Deadline 3 – South Ribble Borough Council Response to Examining Authority’s Written Questions and Requests for information ExQ1)

Planning Inspectorate Ref: EN020028

Morgan and Morecambe Offshore Wind Farms Transmission Assets

Drawing Number:
BP-GBR-MORG-REG-0185

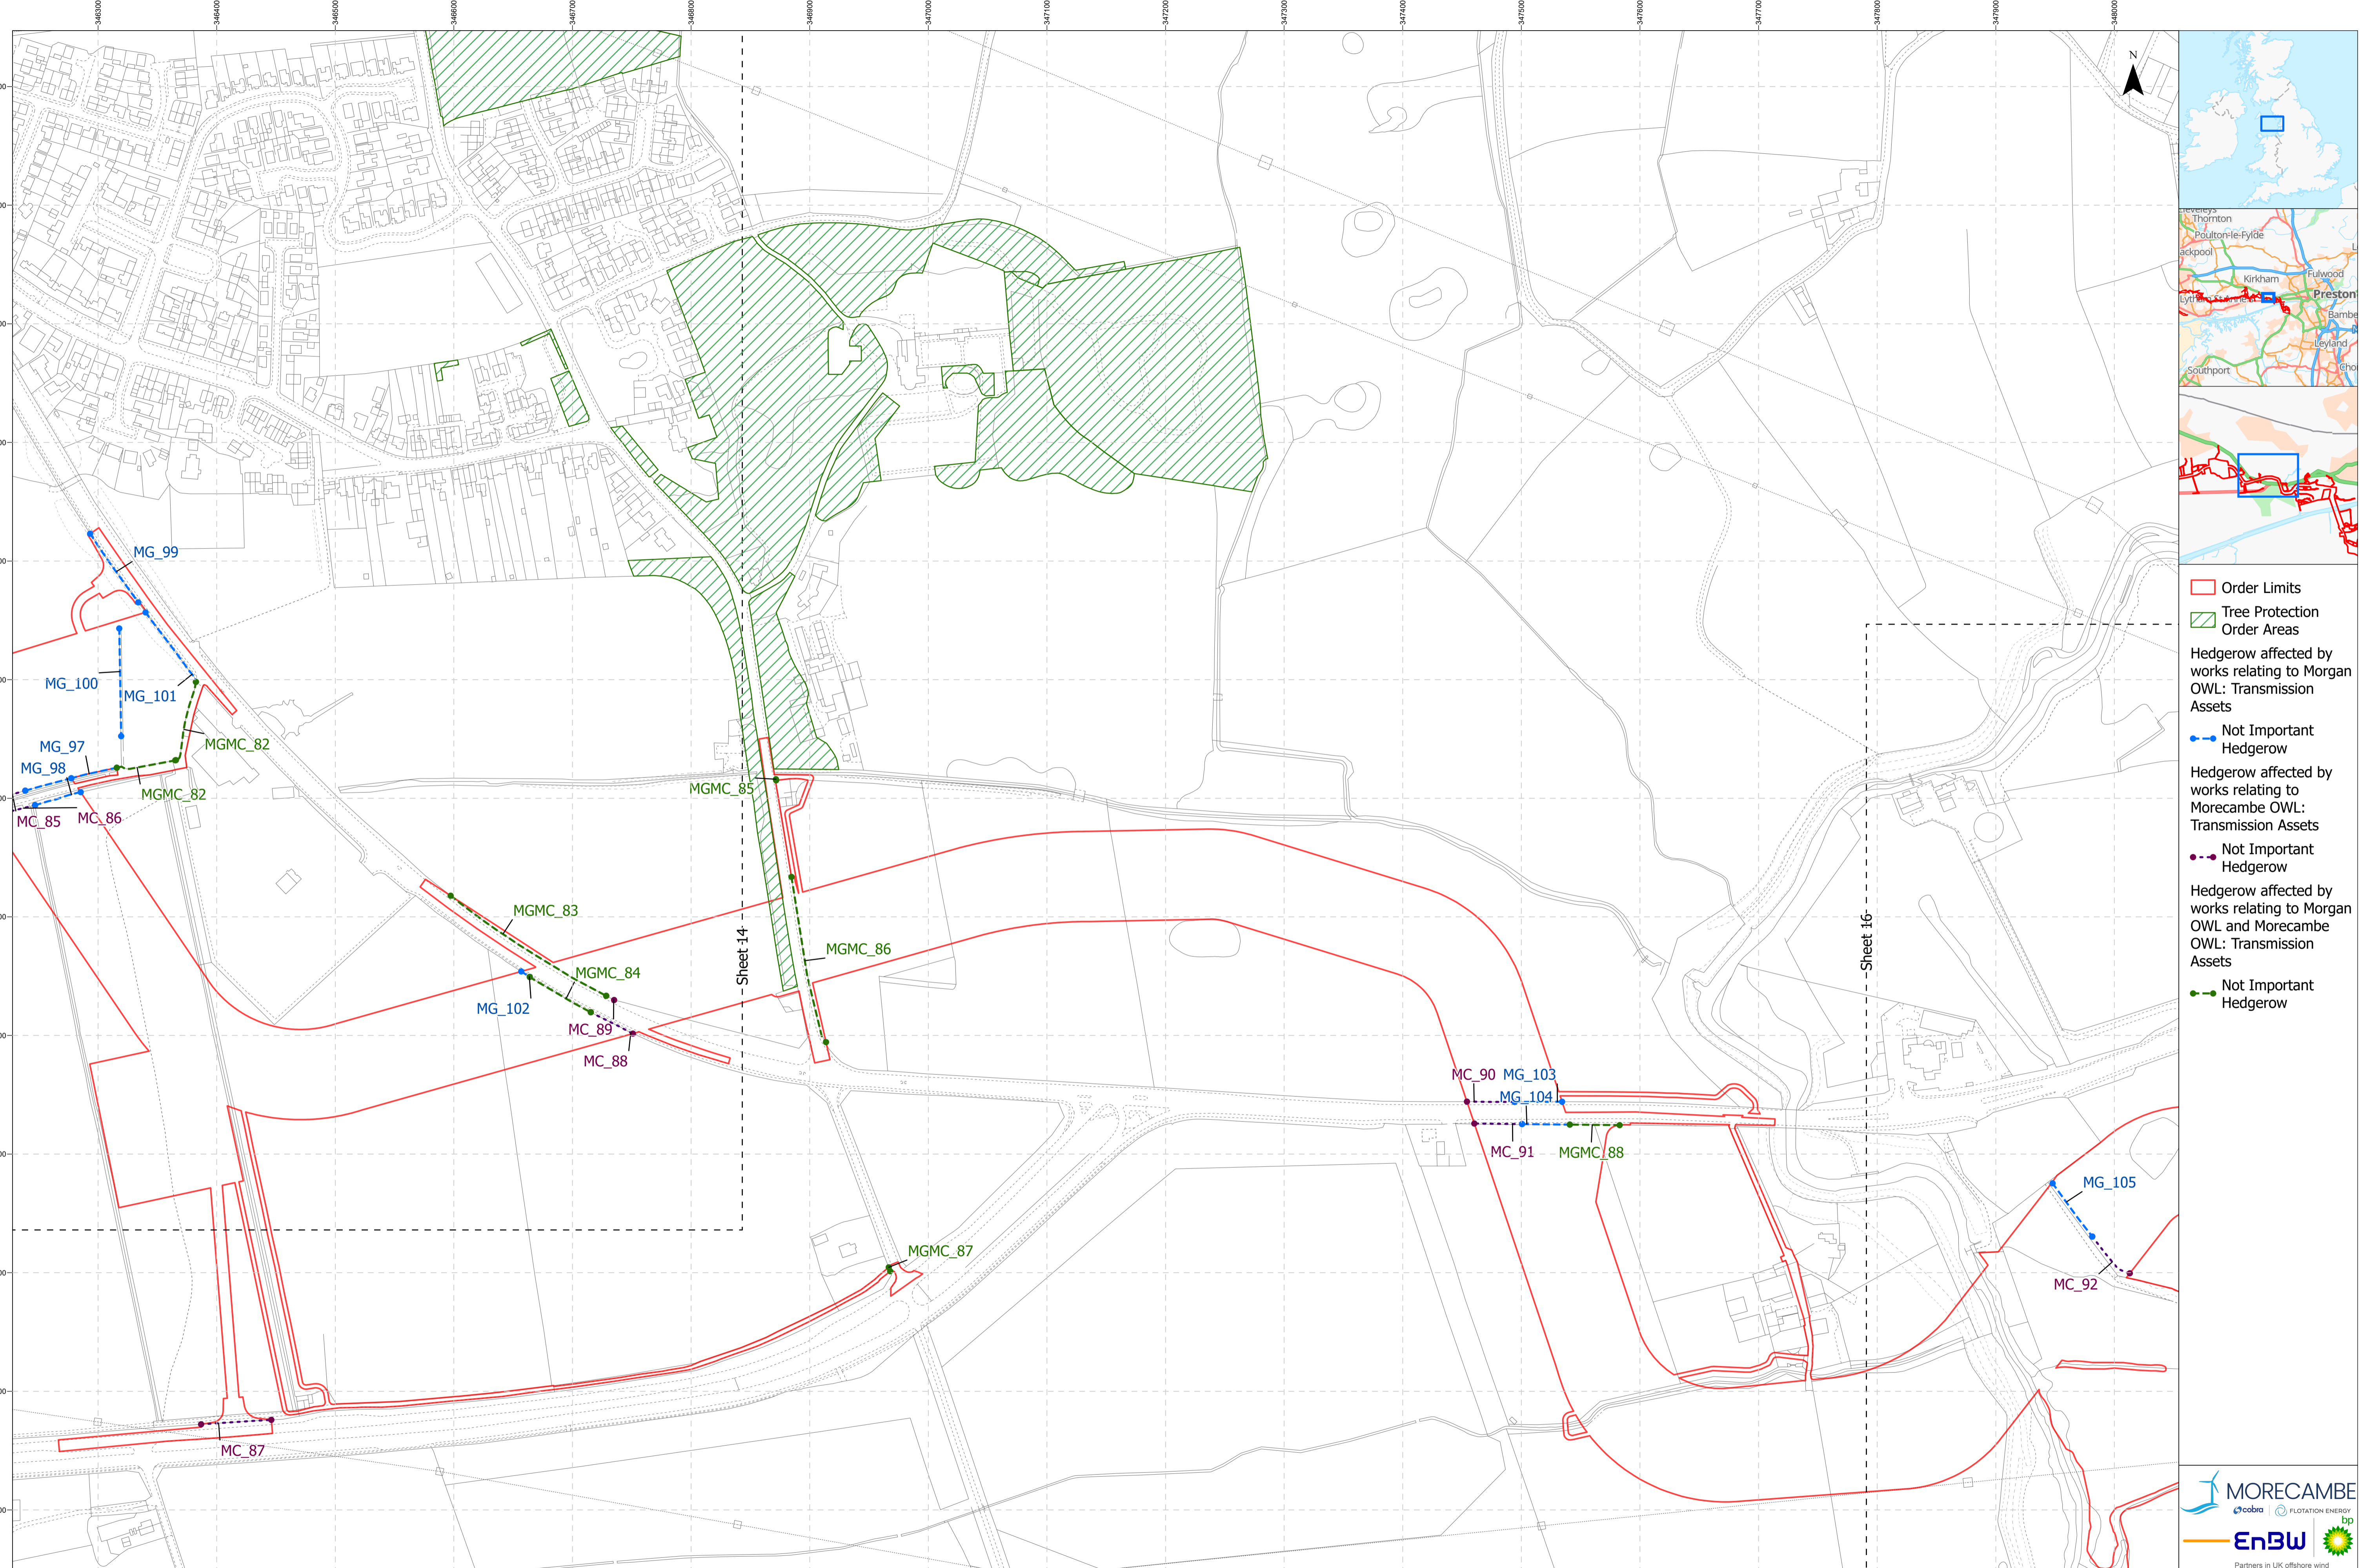
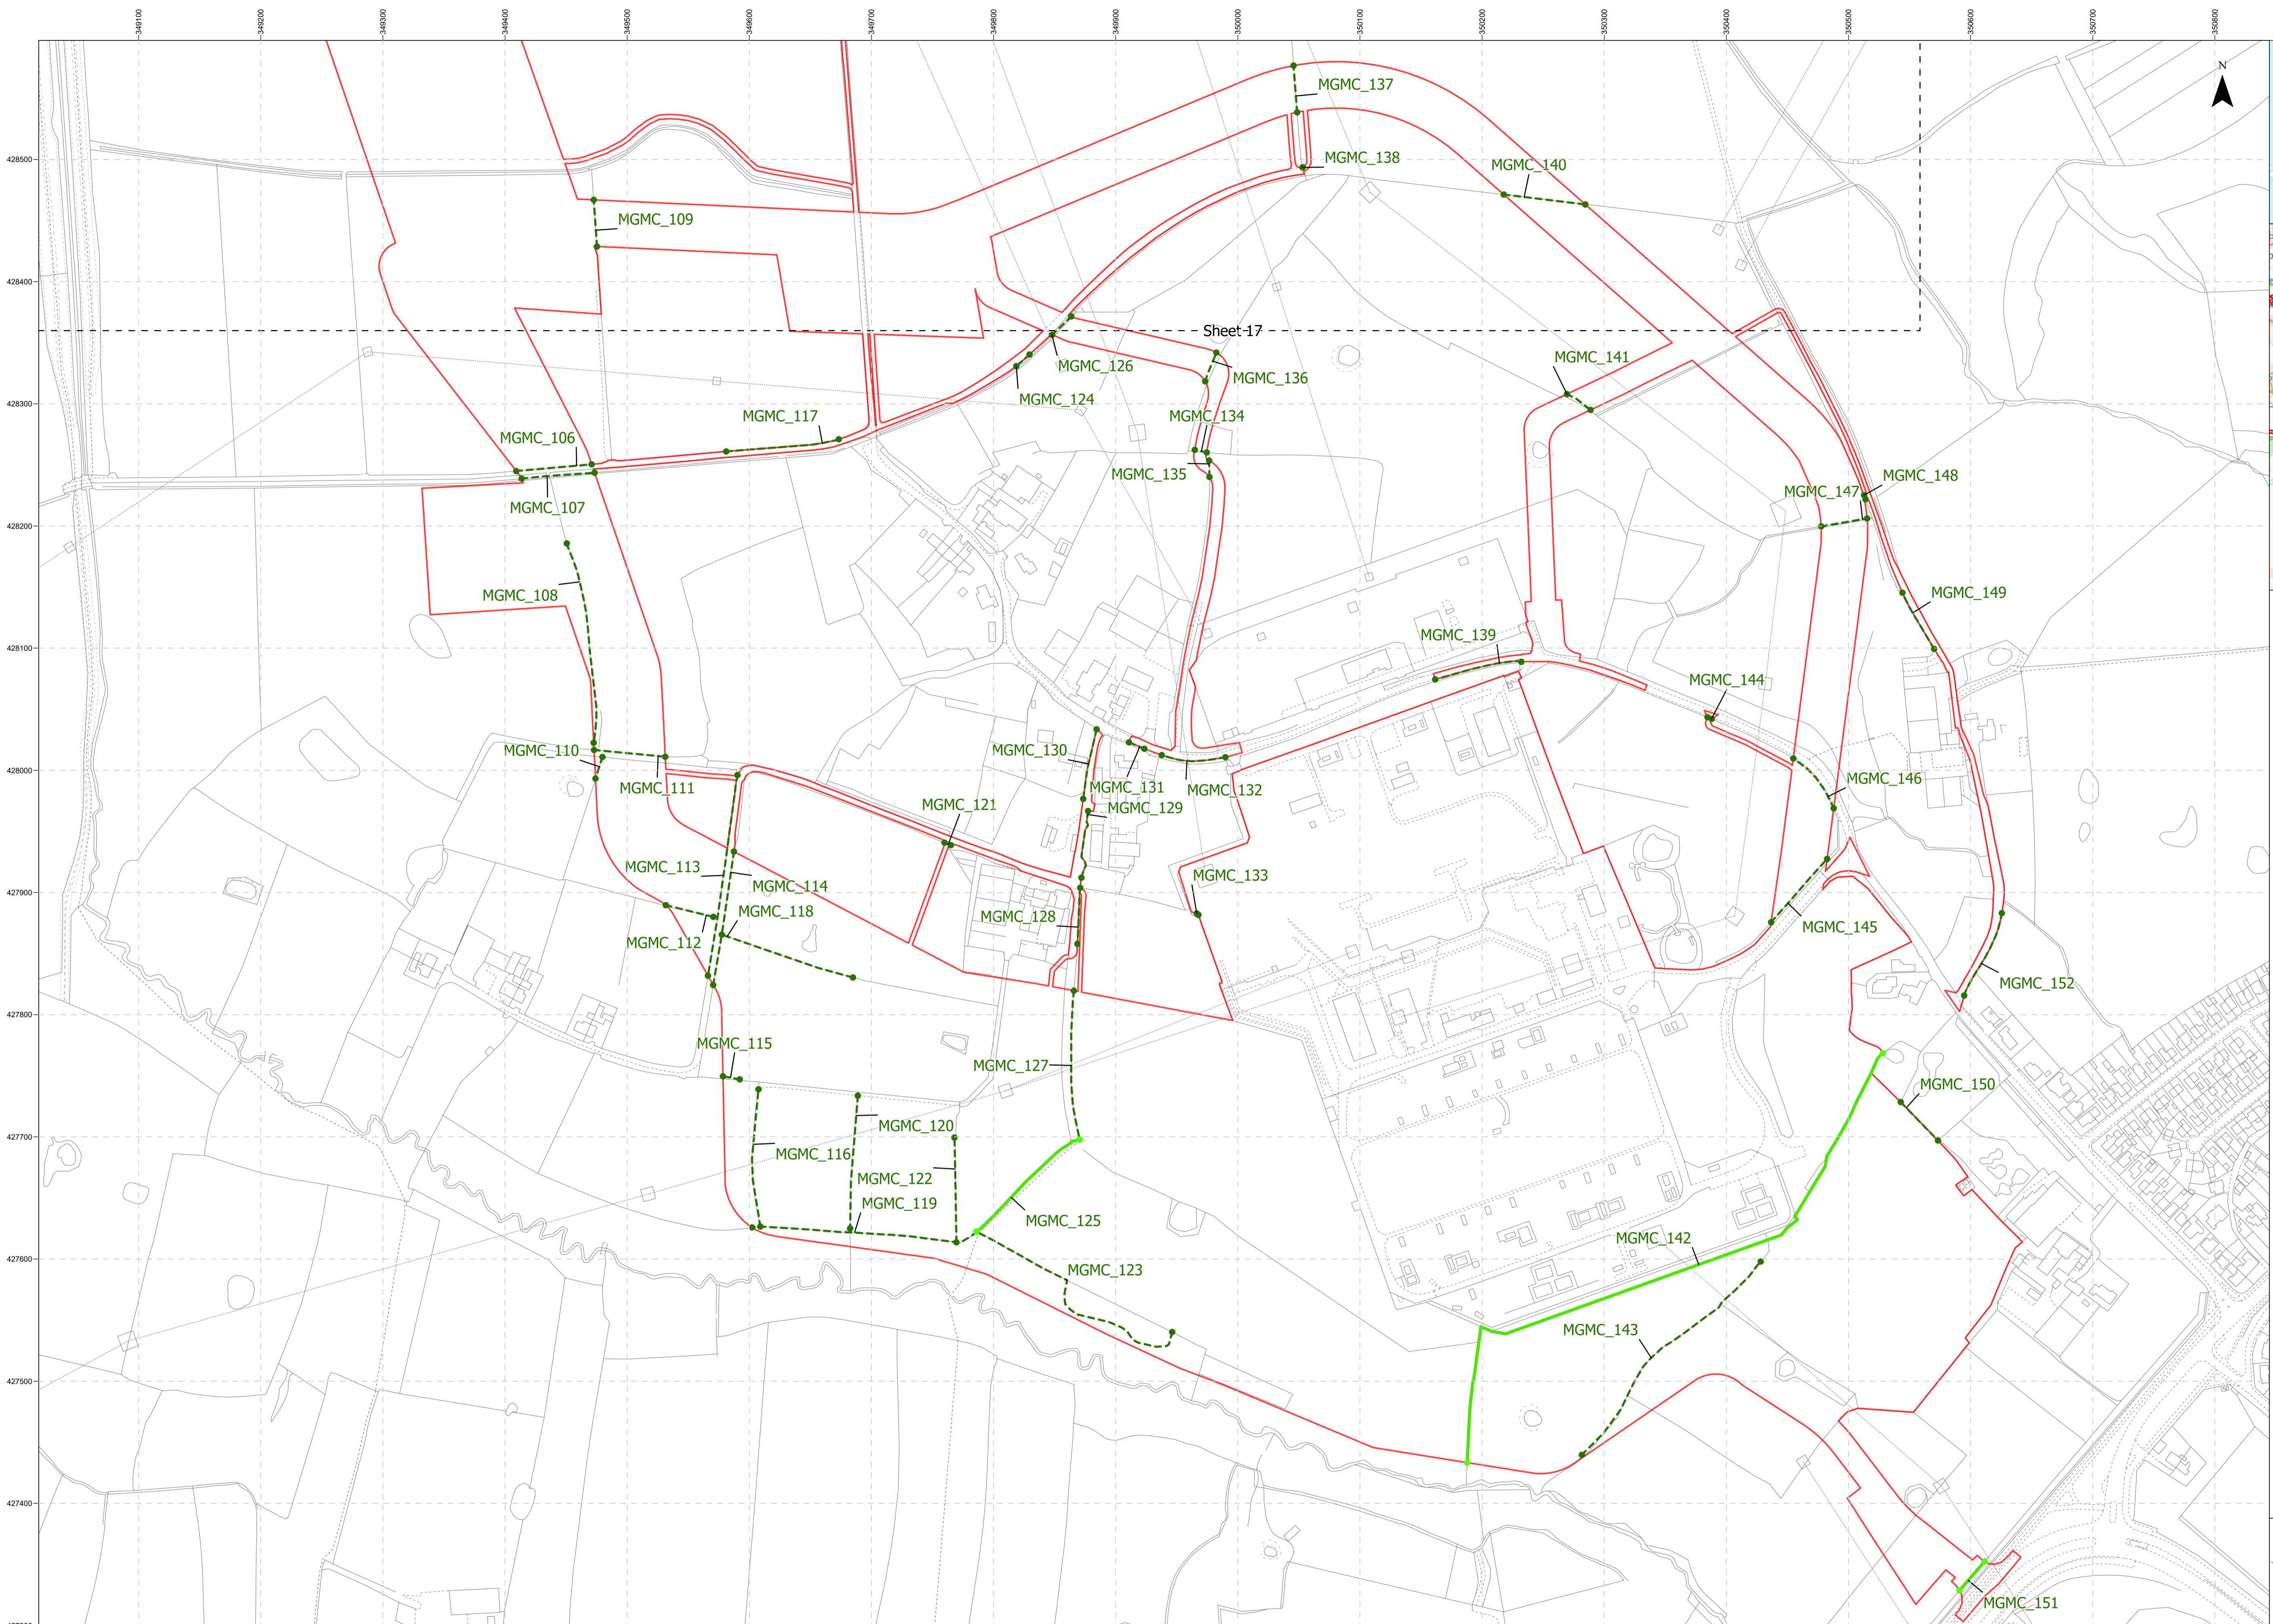
It is noted that construction access 19A19B and cable corridor 34A34B are shown on BP-GBR-MORG-REG-0185 (APP-167) by ref MGMC141 as running through a protected woodland, but otherwise there do not appear to be any other trees that would warrant protection aside from the existing within South Ribble.
